Re: BusConnects Ballymun/Finglas to City Centre Core Bus Corridor Scheme
Ballymun/Finglas to Dublin City Centre

Case Reference No. HA29.314610 – Ballymun/Finglas to City Centre Core Bus Corridor Scheme

15 November 2022.

Drawing Title: BALLYMUN / FINGLAS TO CITY CENTRE CORE BUS CORRIDOR SCHEME  
JUNCTION SYSTEM DESIGN  
GRIFFITH AVENUE / ST. MOBHI

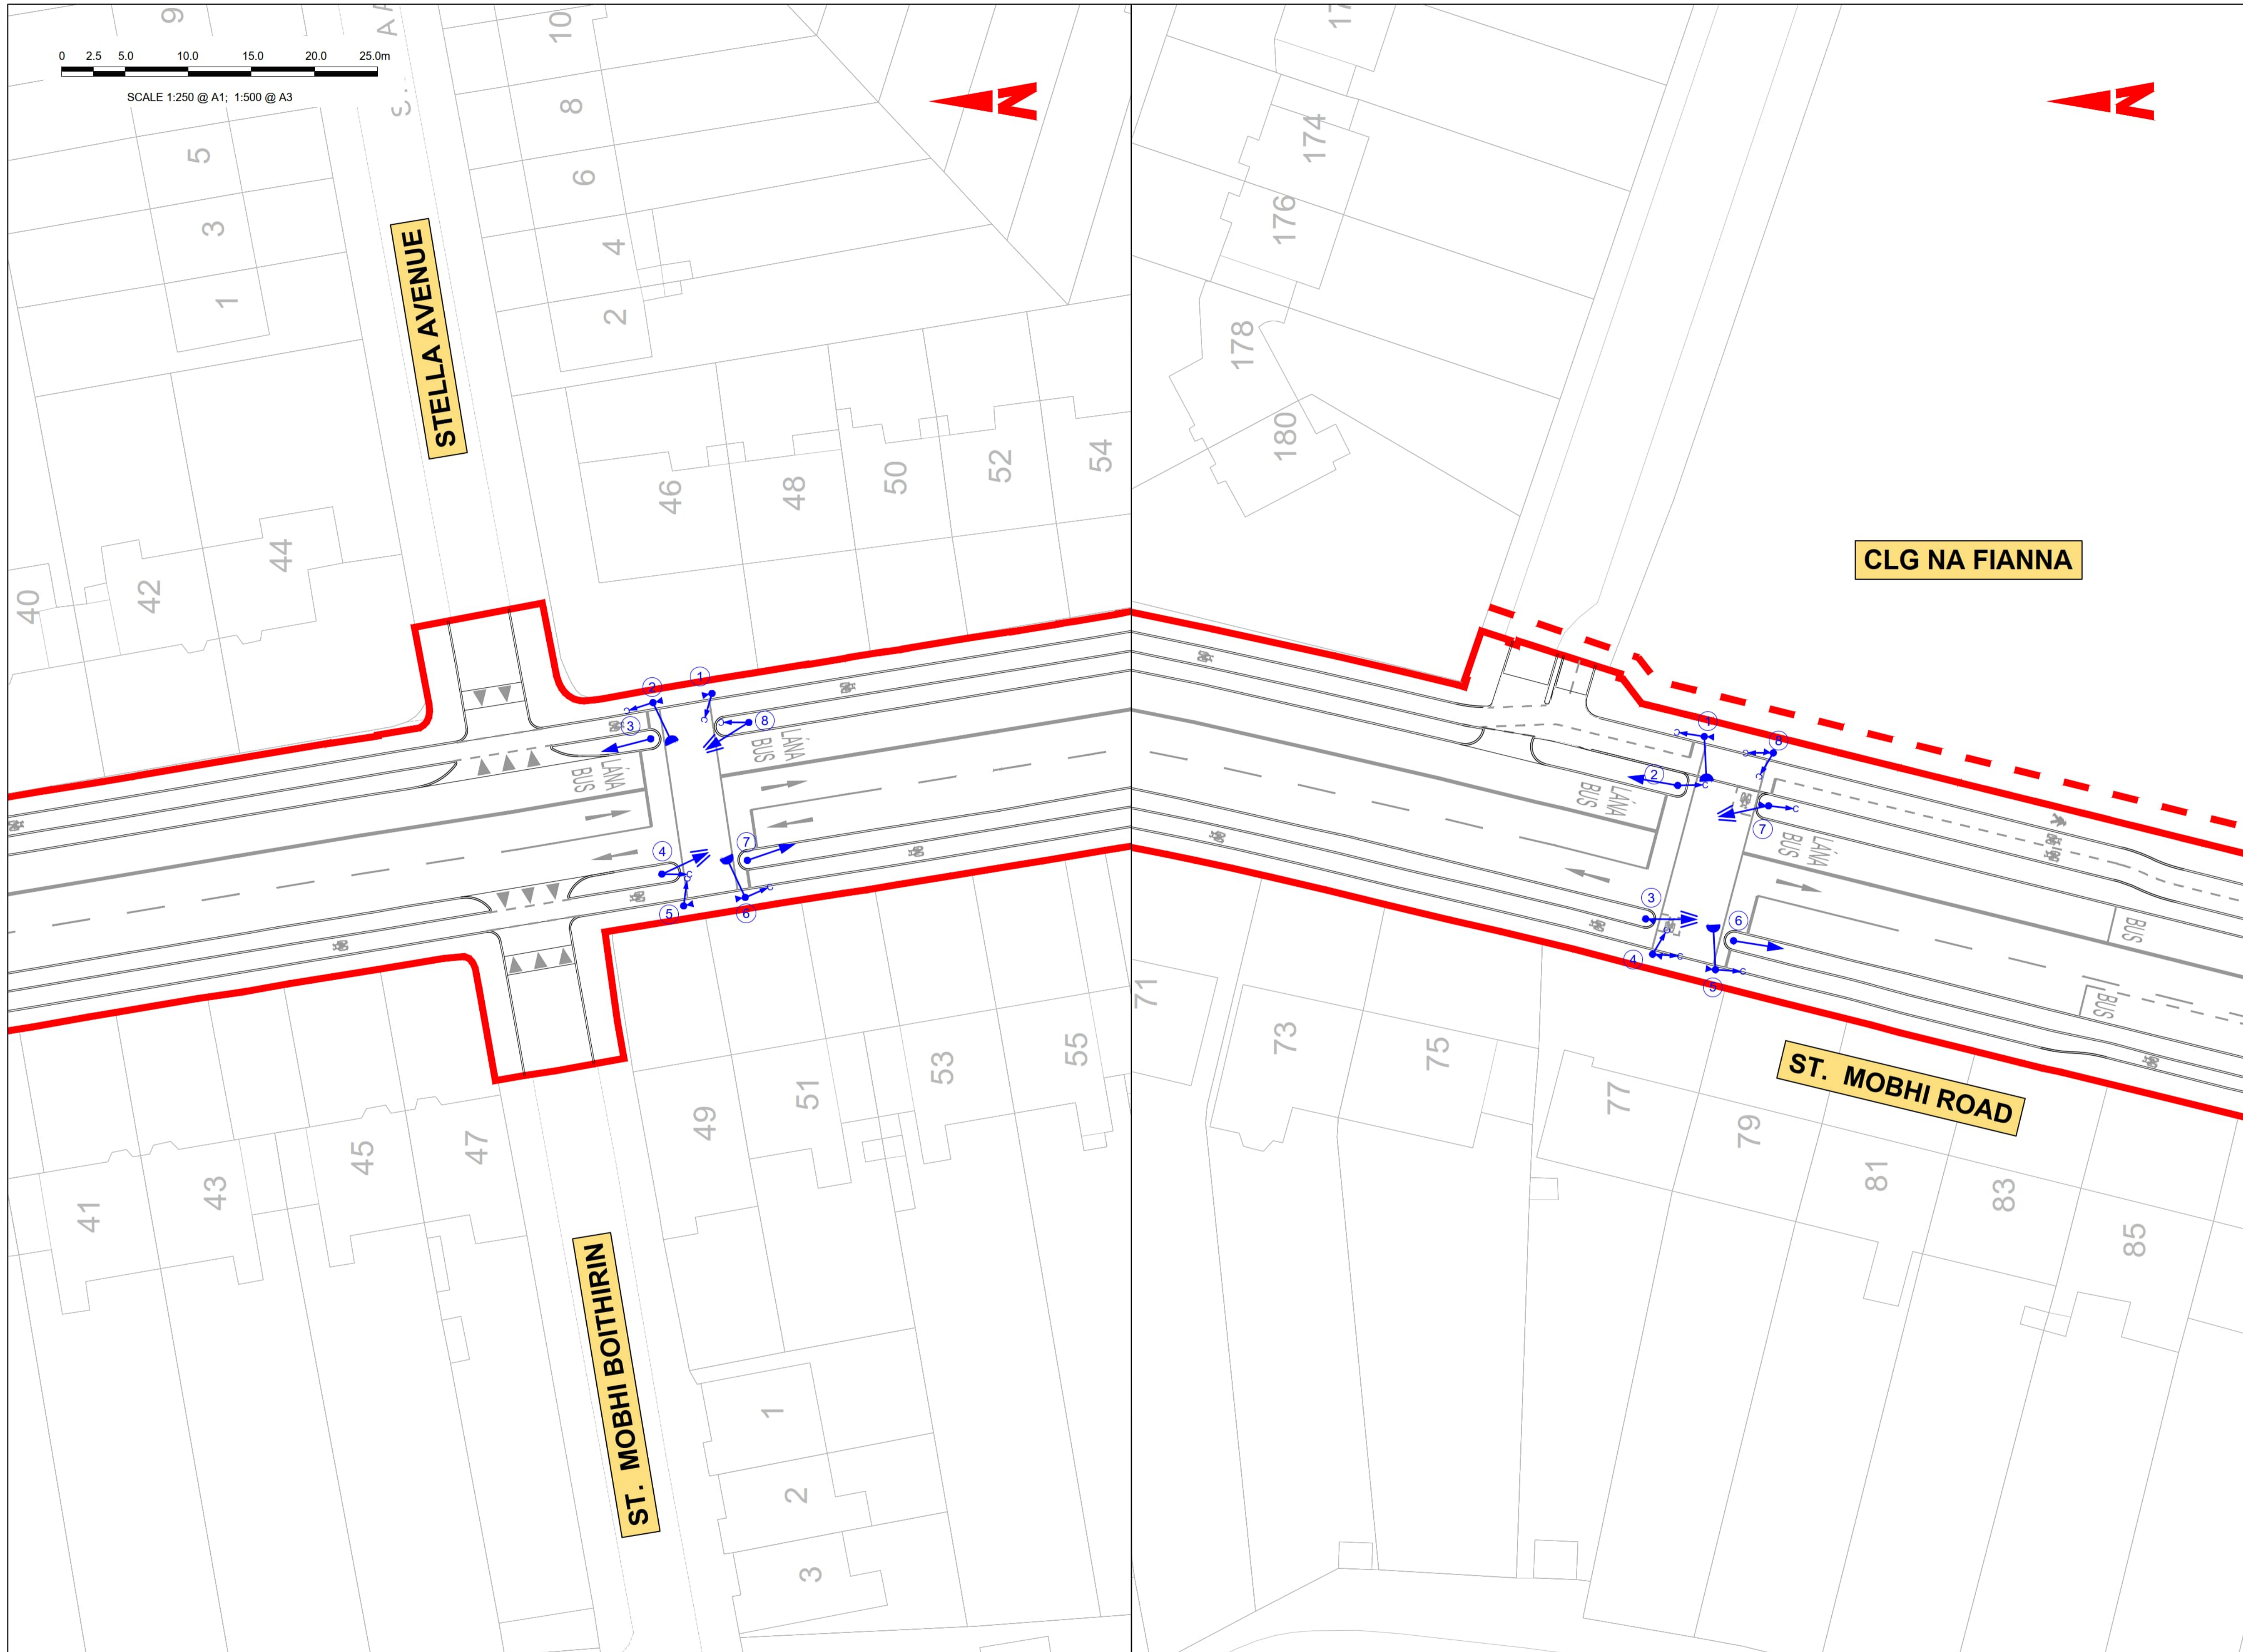
It is not at all clear how the operation of a bus gate at the St. Mobhi Rd./Griffith Ave. intersection can be enforced. If it cannot be enforced, the envisaged improvements in traffic flow cannot be realised.

We understand the rationale for the proposed ban on cars making left turns into Griffith Ave. East from St. Mobhi Rd. when travelling south. However, the alternative route proposed diverts traffic right onto Ballymun Rd. at the triangle, making it two-way, and then turning left into Griffith Ave. East, necessitating the removal of traffic islands, recently installed at considerable expense, for the creation of on-street cycle tracks that are barely used and taking more healthy trees and green space from that particular stretch of road. It should be noted that these recent changes have caused huge delays to traffic travelling north on St. Mobhi Rd.
